# ***City of Albuquerque***

**Re: Allrite Roofing Systems, 3040 Painted Rock Drive NW, Grading and  
Drainage Plan**

**Engineer's Stamp dated 9-26-03 (G10/D29G)**

Based upon the information provided in your submittal received 10-09-03, the above referenced plan cannot be approved for Building Permit until the following comments are addressed:

SHEET TITLE:  
GRADING PLAN

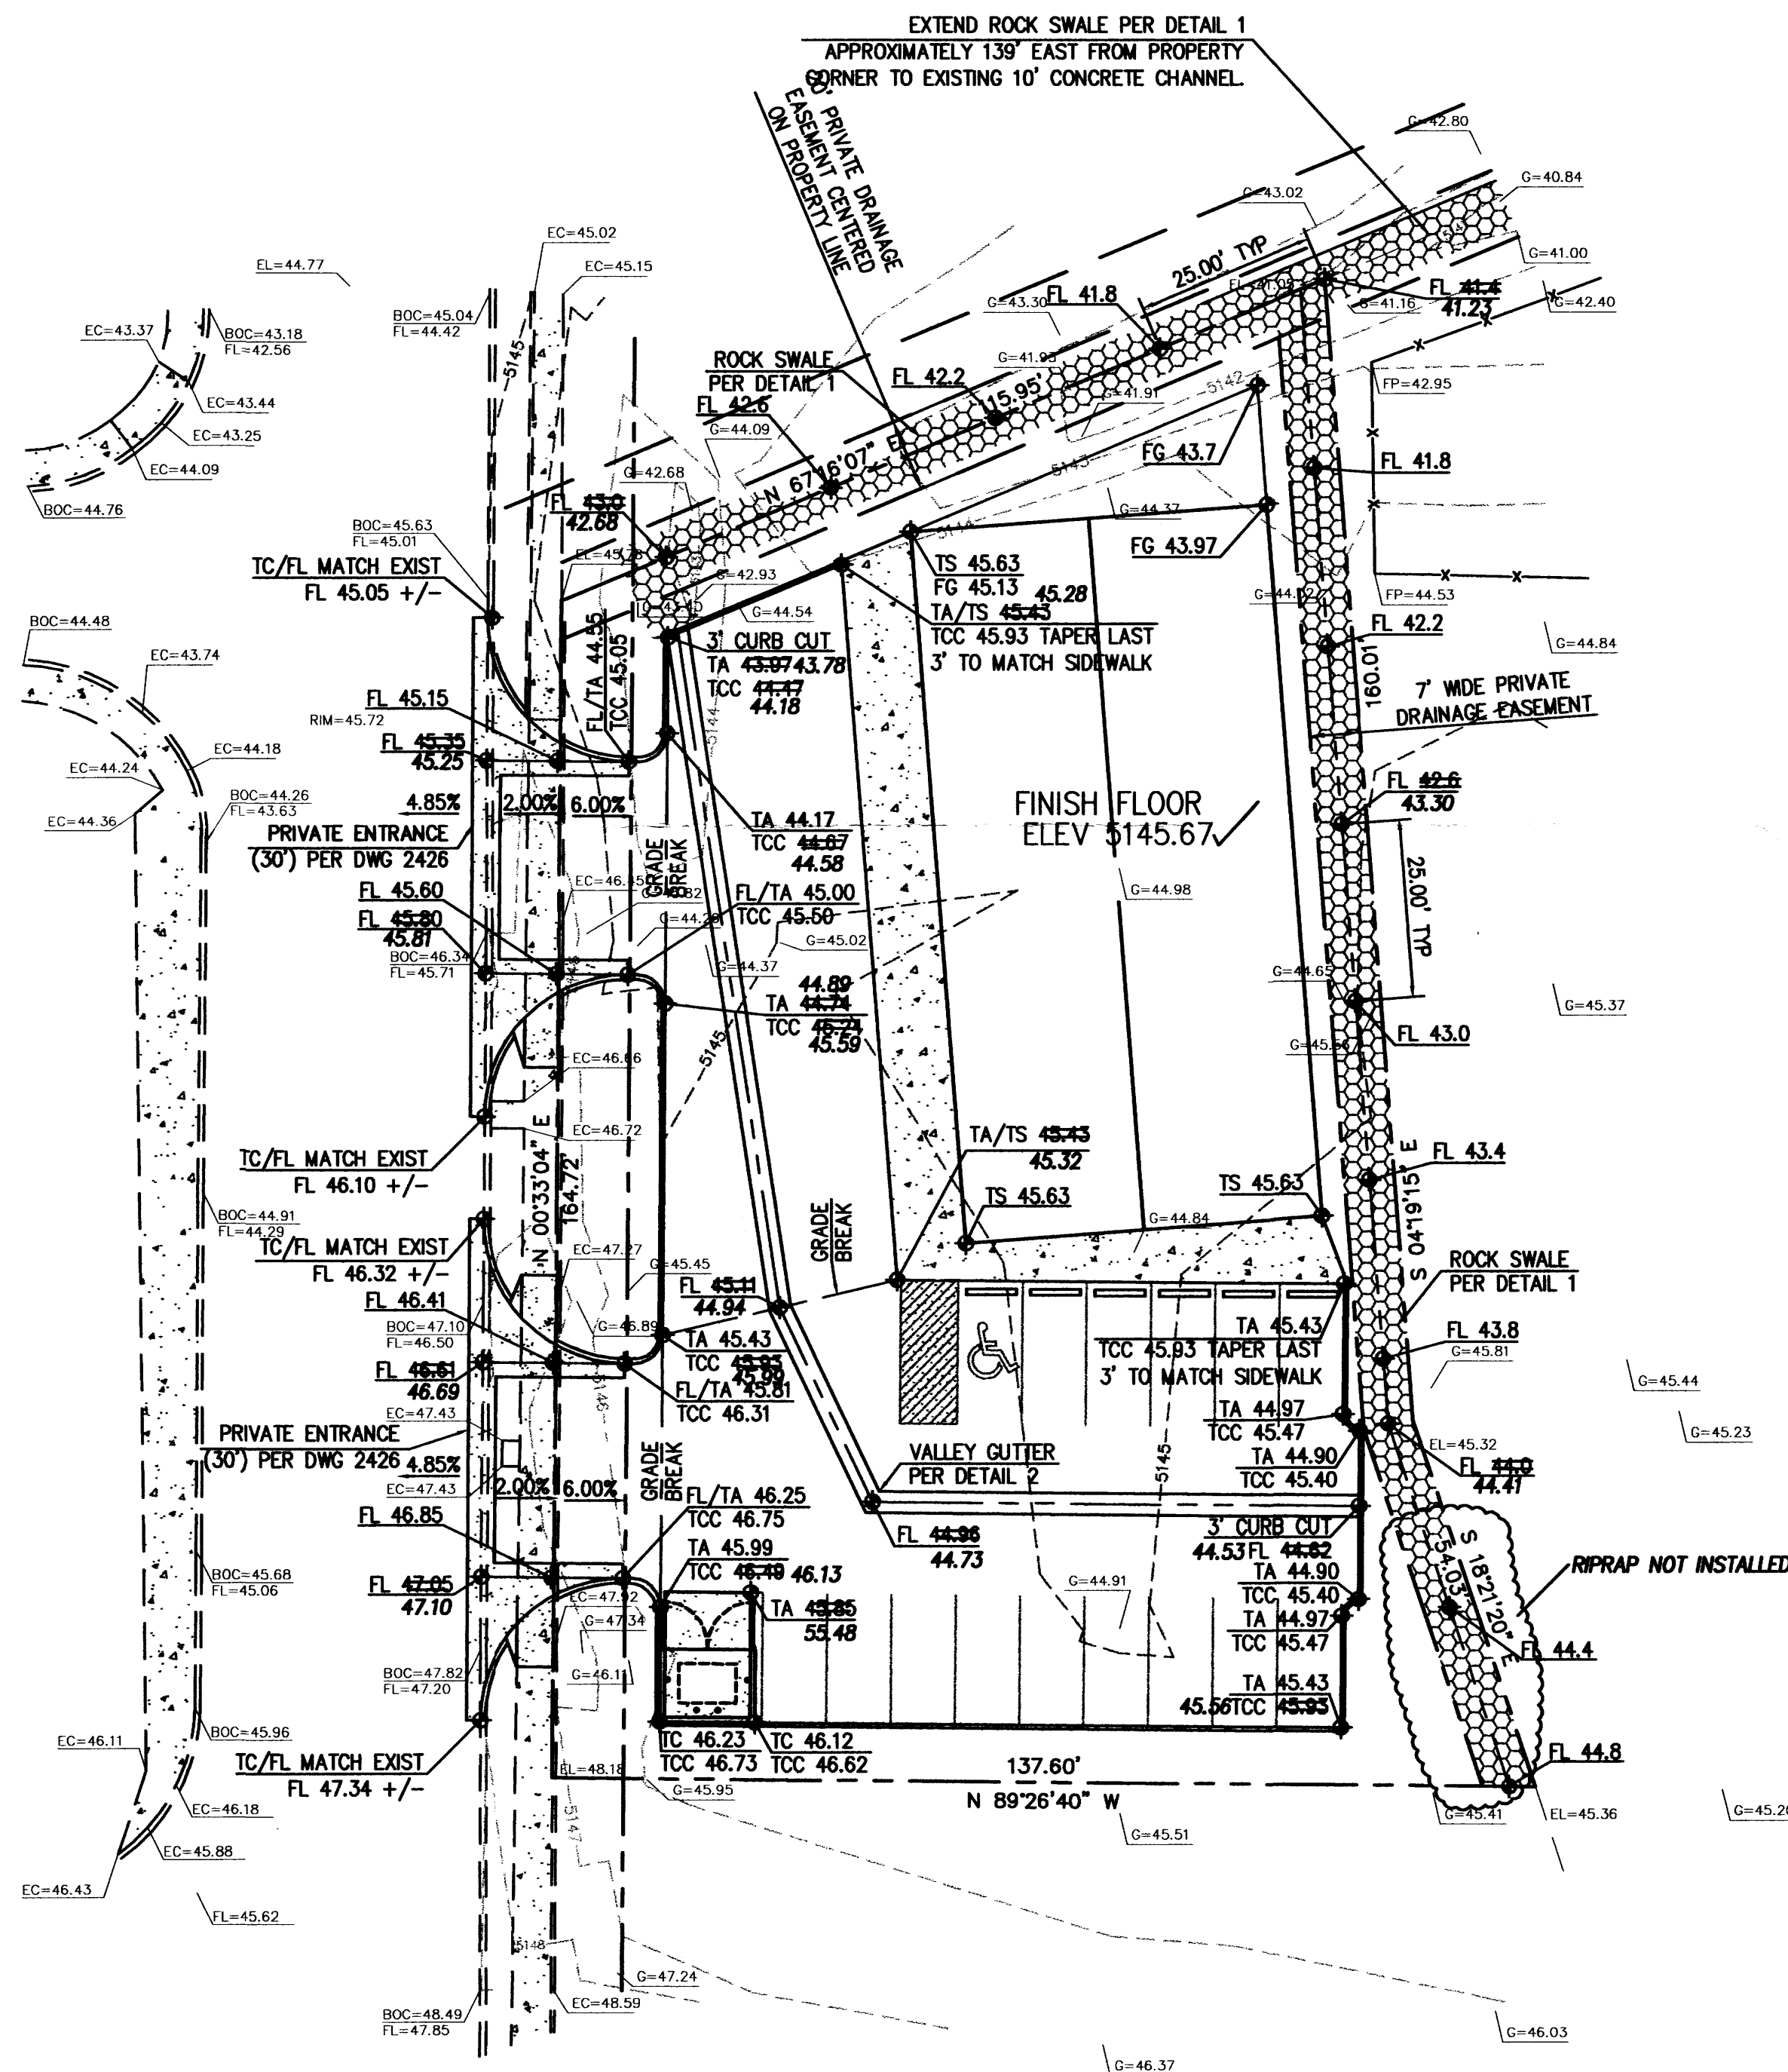
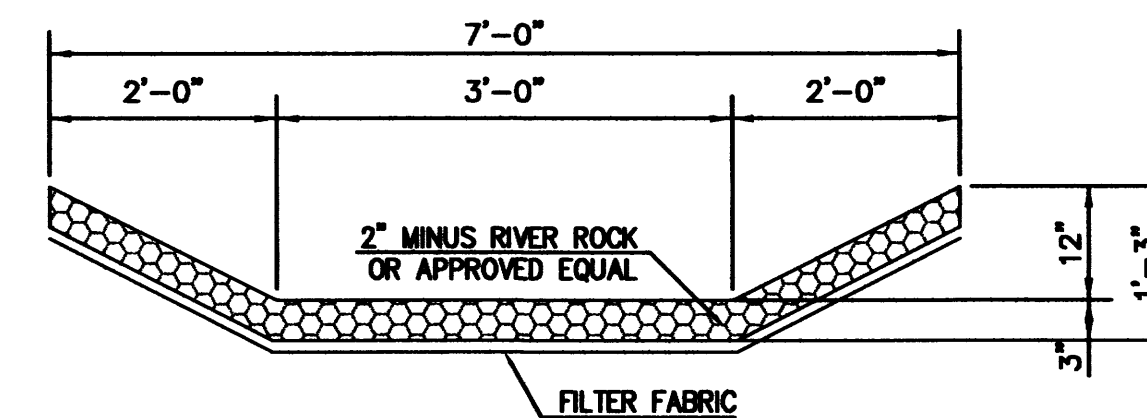
1. Address the downstream capacity of the northern swale between Painted Rock Dr. and Todos Santos St.
2. Label all easements.
3. Who is responsible for maintaining the northern and eastern swales? If the City is responsible for their maintenance, the swales must be brought up to City standards.
4. Prove quantitatively which sites are allowed free discharge.
5. Please address the size and capacity of the north and east swales if the properties upstream of the swale are allowed free discharge.
